Please upload the below to the above application: Drainage Engineers comment.

In terms of the proposals effect on the existing suds (surface water drainage system), I would like to make the following comments;

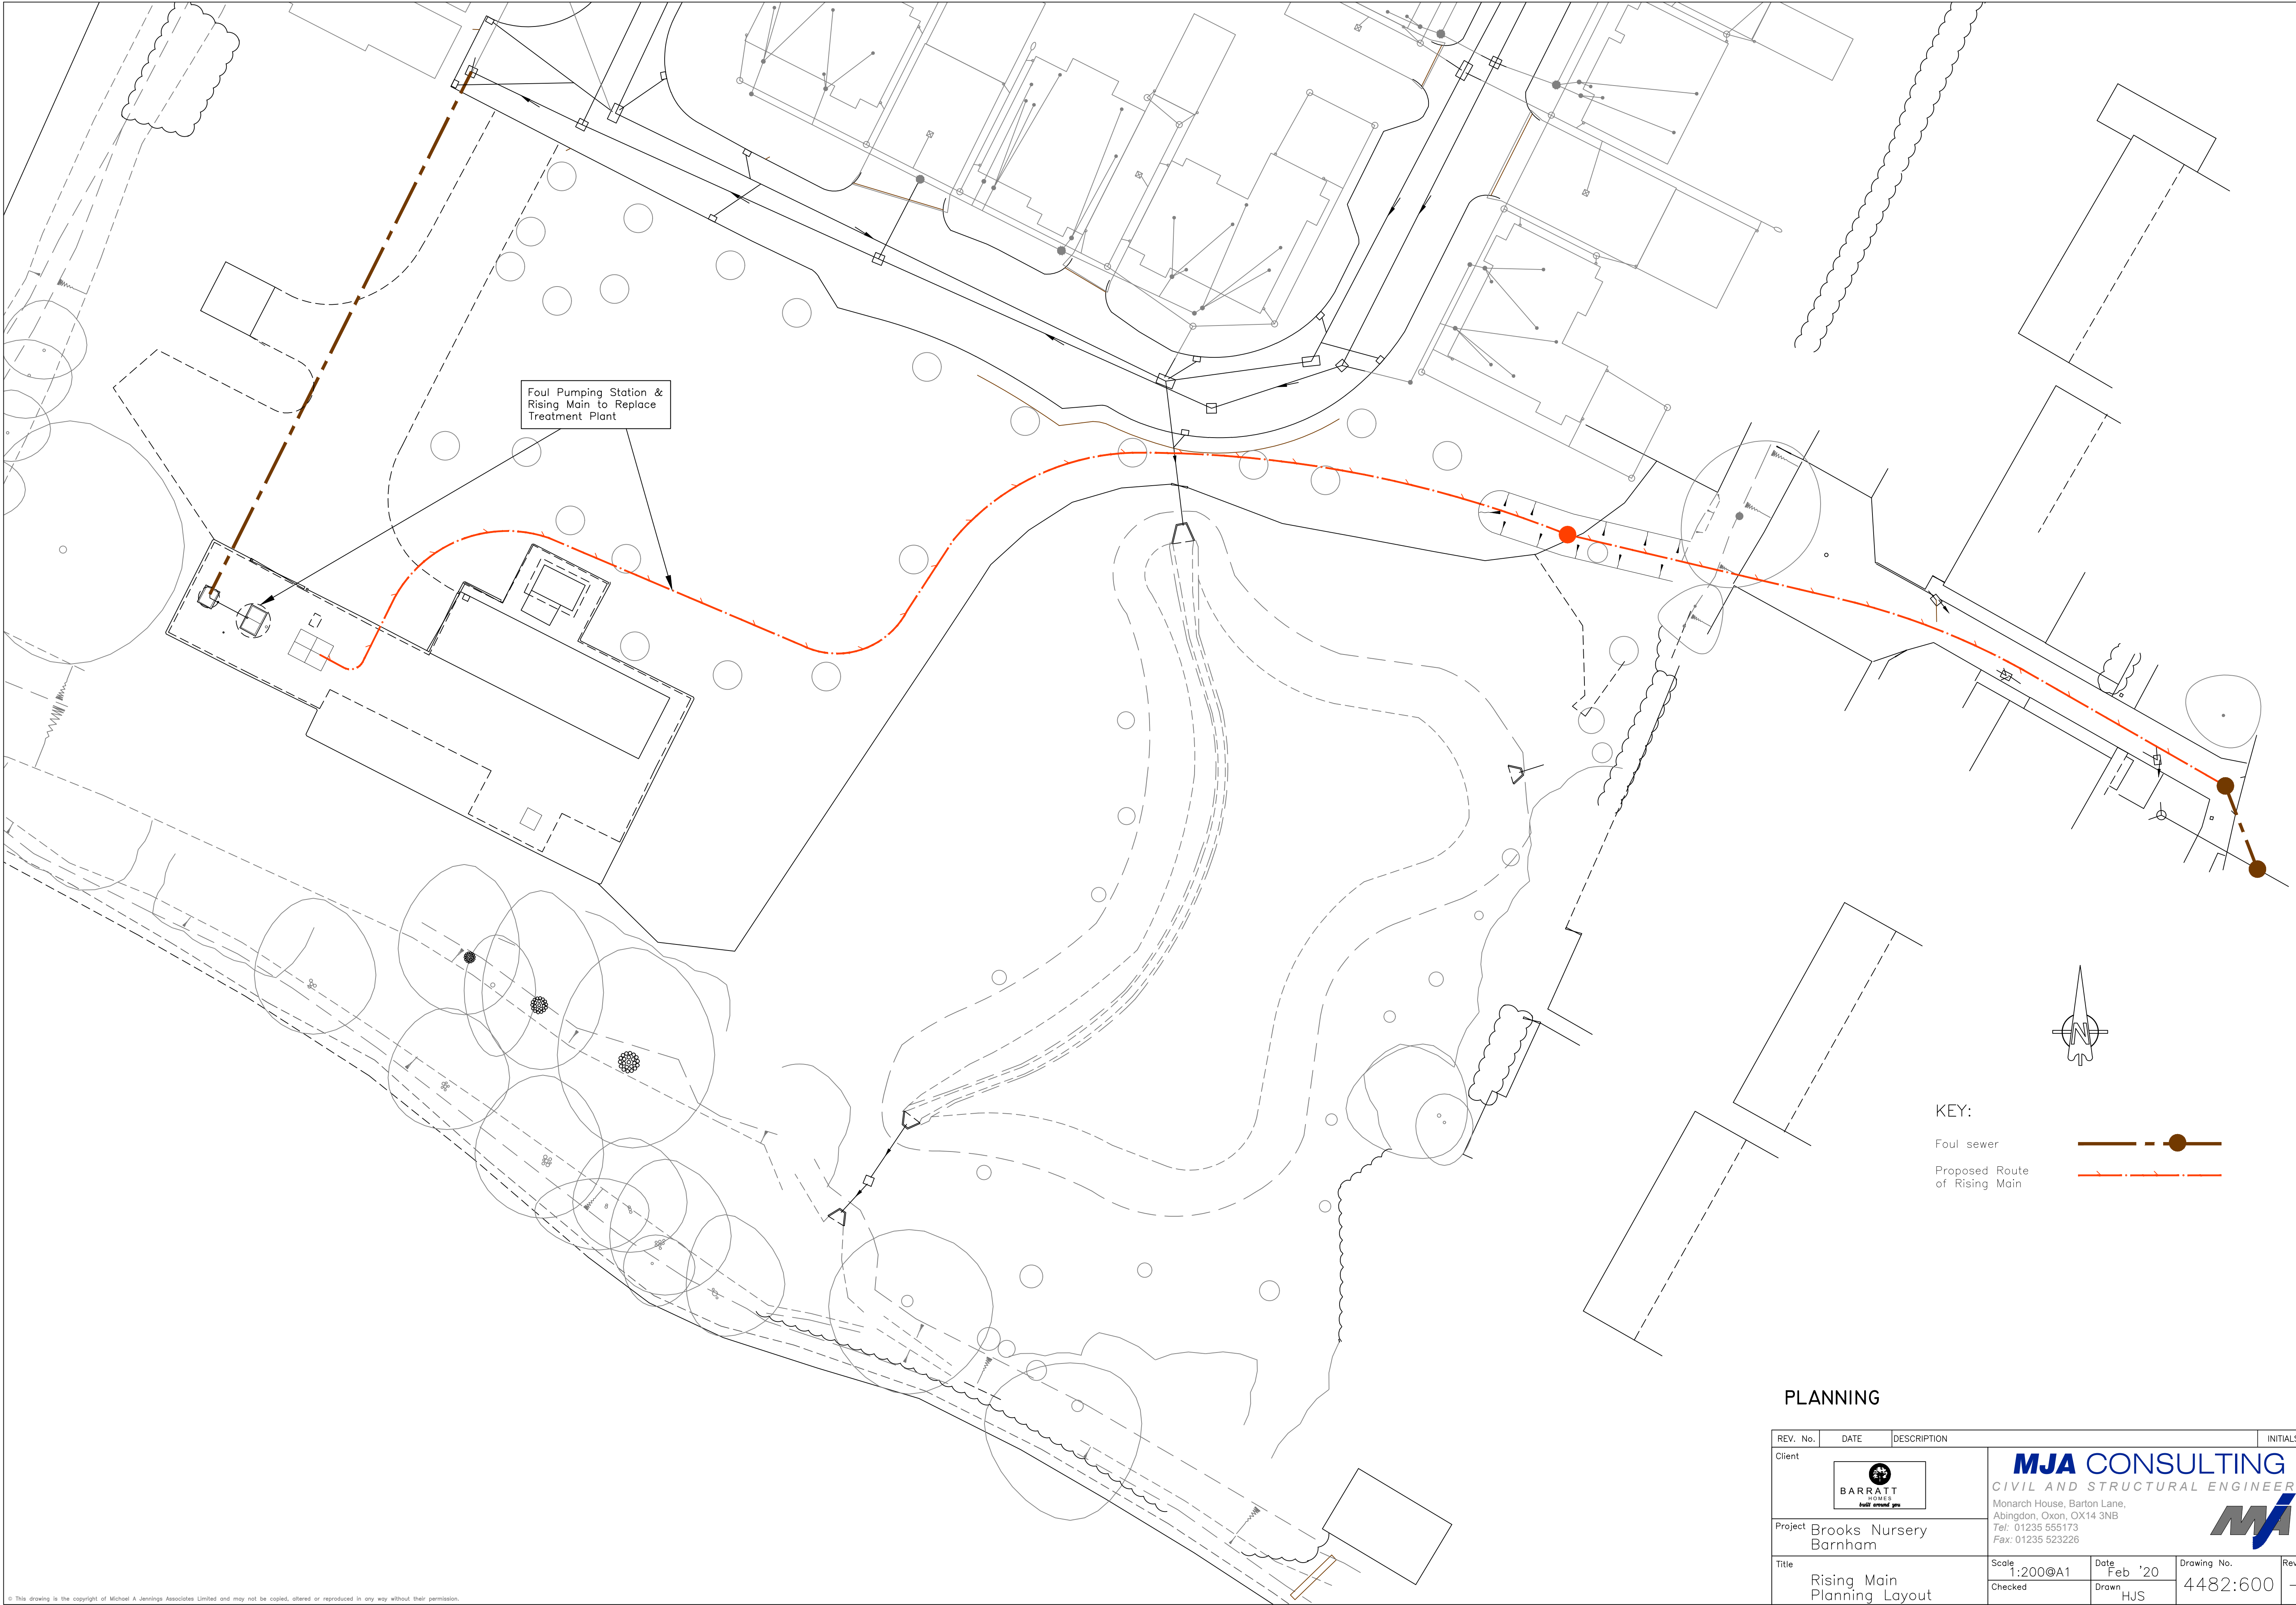
- The small outfall ditch for the treatment plant was not part of and did not contribute to the overall volume within the surface water attenuation design, this was purely an outfall for the foul treatment plant. By not filling the ditch in would potentially create a dead stagnant spot for water, as this won't be part of the natural flow path. The original pond calculations are attached for clarity. Noted but calcs not included in email.
- The rising main section previously submitted was updated following discussion with Southern Water, however this was regarding the off-site connection and some manhole details. Nothing has changed regarding the rising main position over the existing surface water outfall pipe. The longitudinal section needs to show the land drain on the eastern boundary to make sure there is no clash with the rising main.

| Title       |          | Foul Outfall Rising Main Details            |          |

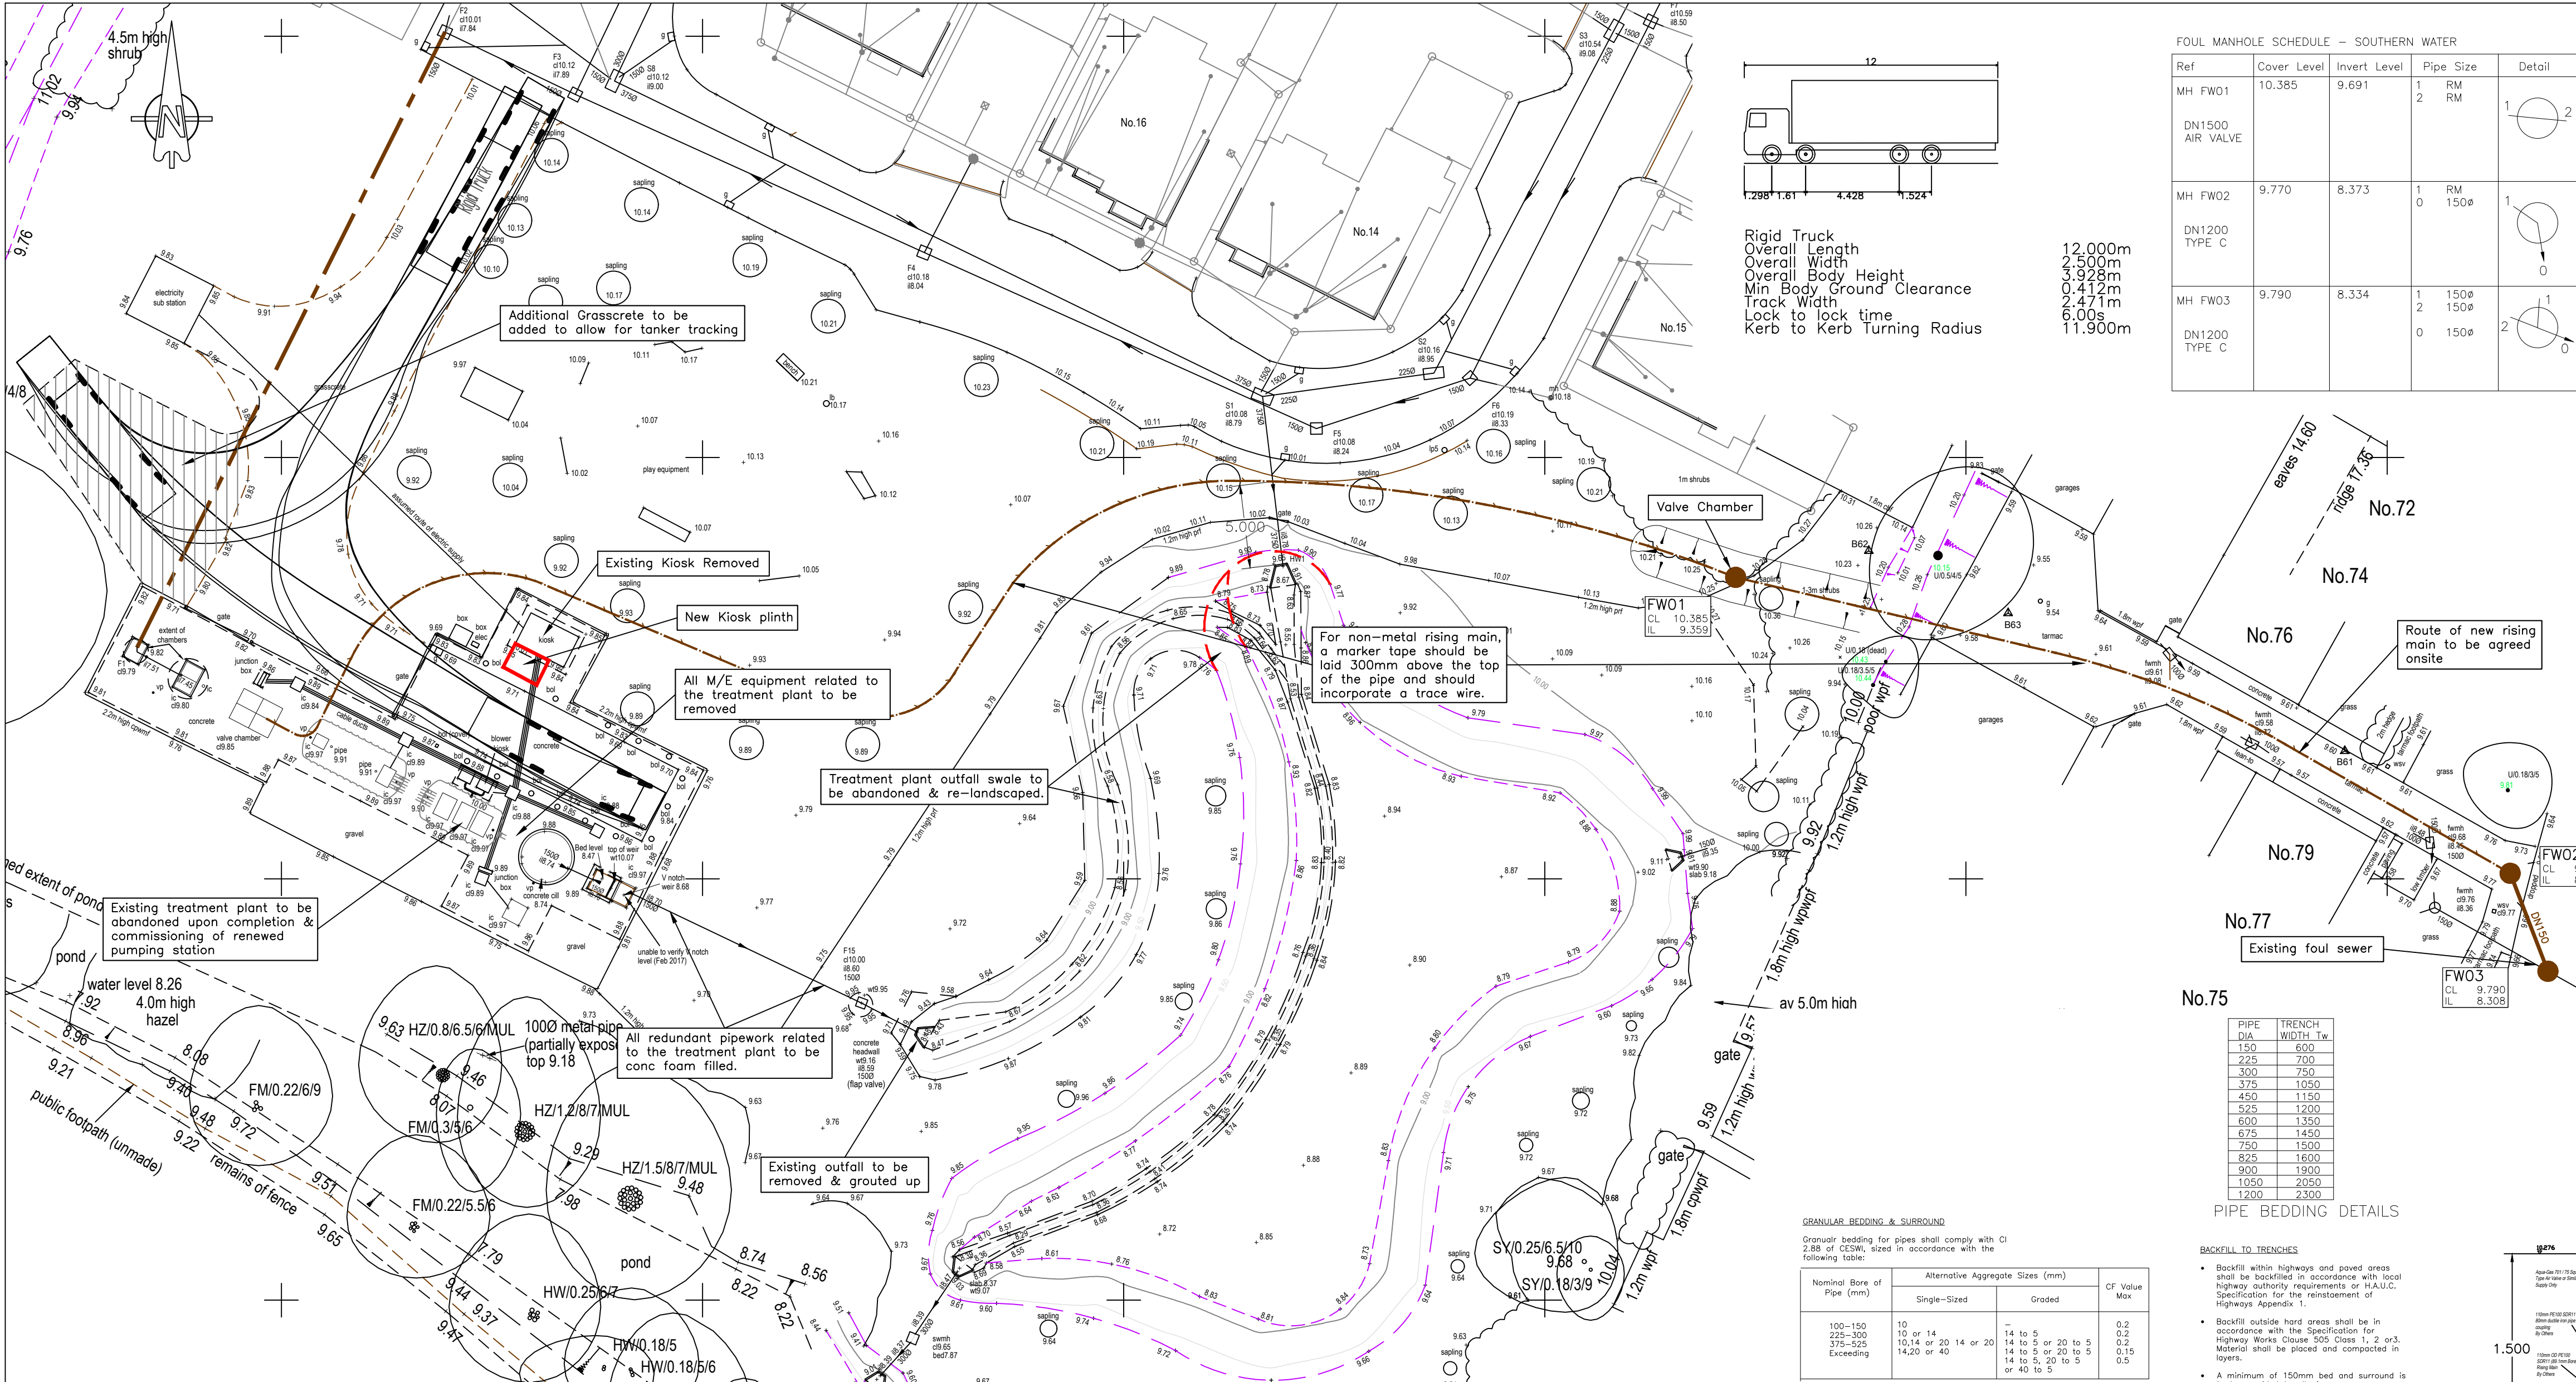
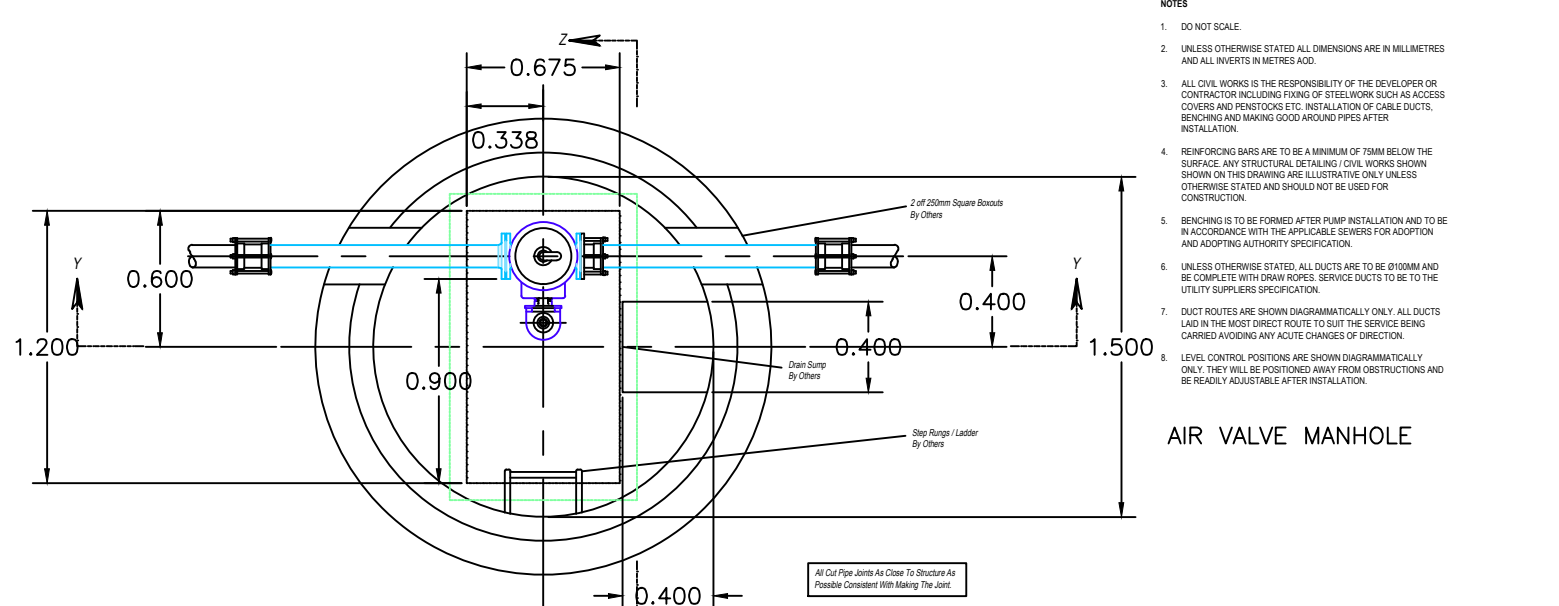
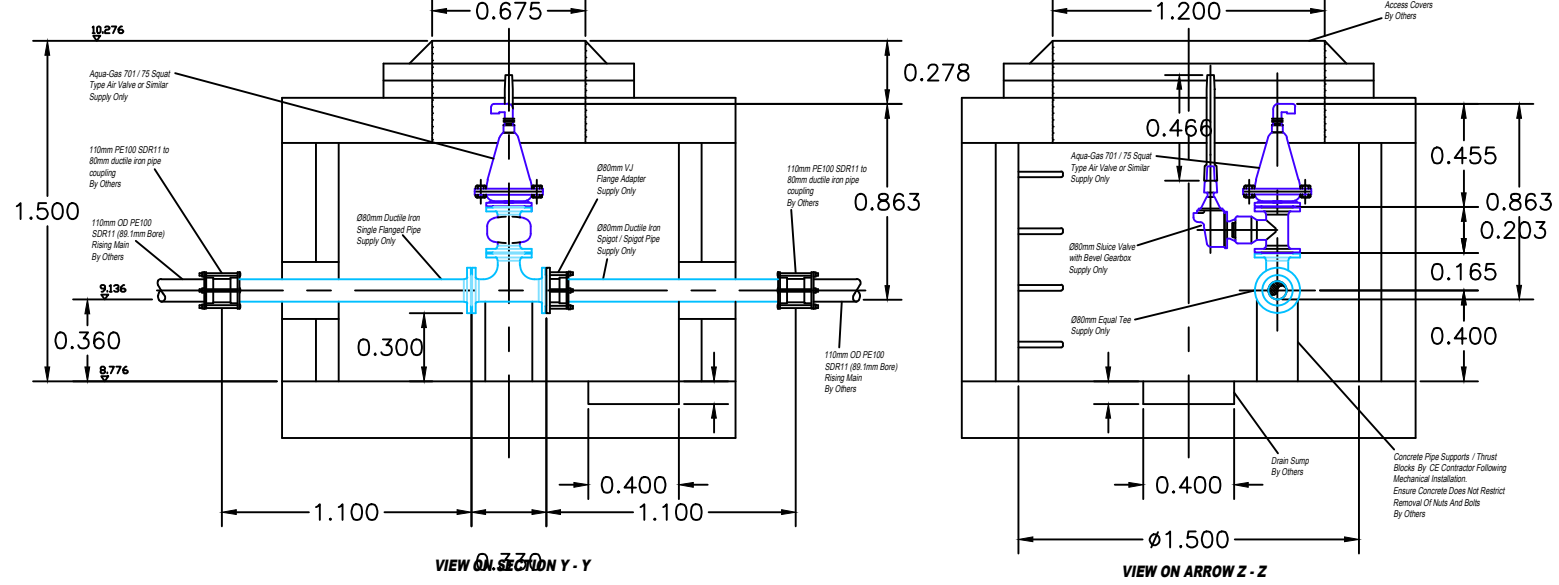
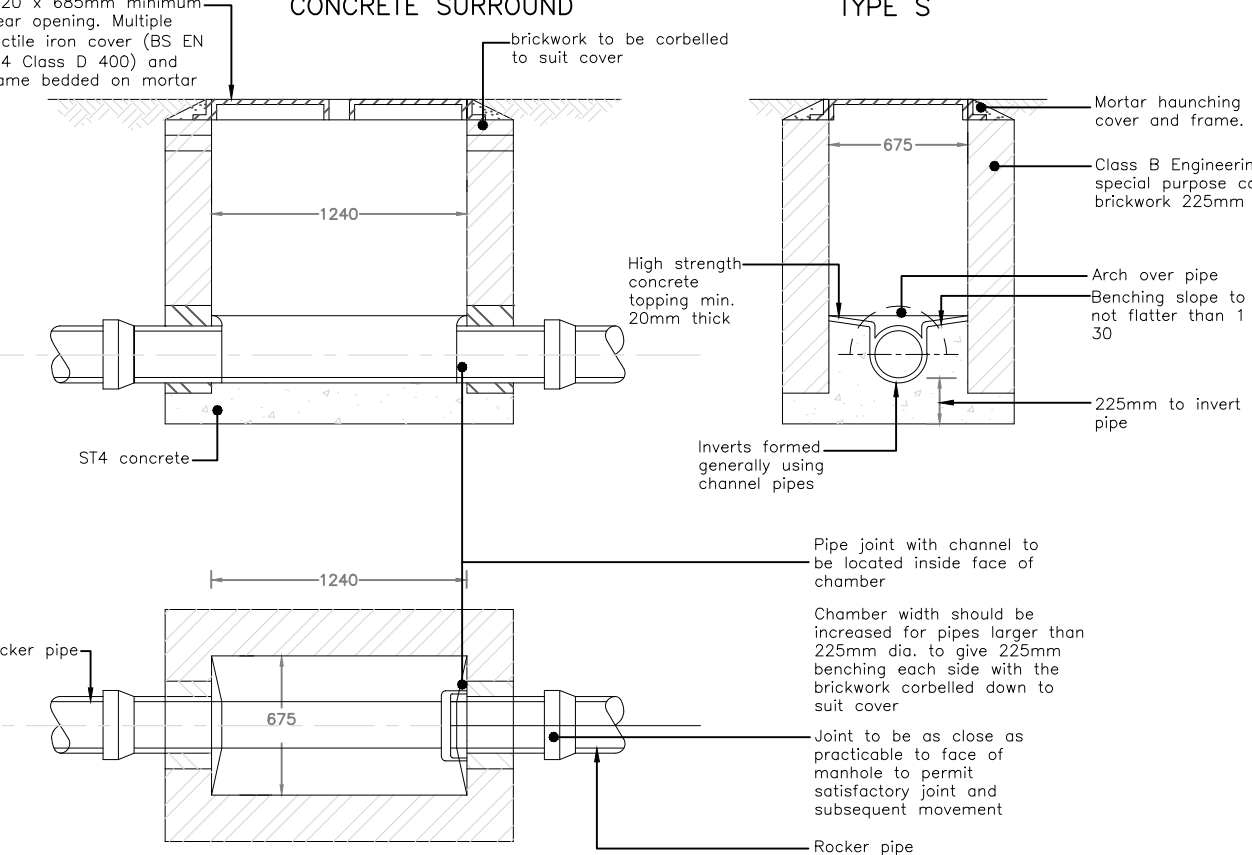
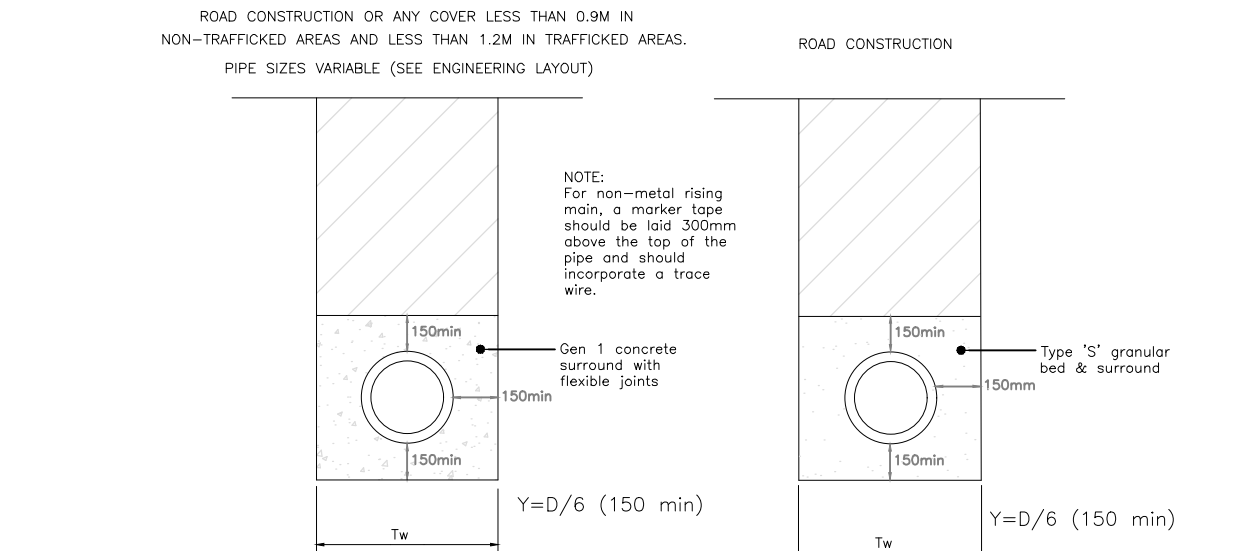
The long section is now ok, however, the note regarding the abandonment of the channel needs to be changed ie. to be retained. Once this is done, then the proposals meet with my approval.

Just for clarity, is the effluent ditch to be retained or infilled. Your email suggests it will remain but the drawings show it to be filled. I have no objection either way.

- a) The open channel/ditch in which the sewage treatment plant discharges into at present, before it connects into the suds pond, is proposed to be infilled.
The applicant will need to provide written confirmation with supporting calculations to prove that the storage for surface water within the suds system is not compromised as a result.
- b) Where the proposed rising crosses the incoming surface water outfall to the pond and the known land drain running parallel to the eastern boundary of the development, the applicant should provide a longitudinal section to prove no impact on these pipelines.

See attached updated plan as requested for clarification

Please find attached an updated plan as requested

Finally, the long section requested was already shown on drawing no, 4482.510A , which I attach for reference along with the other engineers drawings which were agreed at the meeting
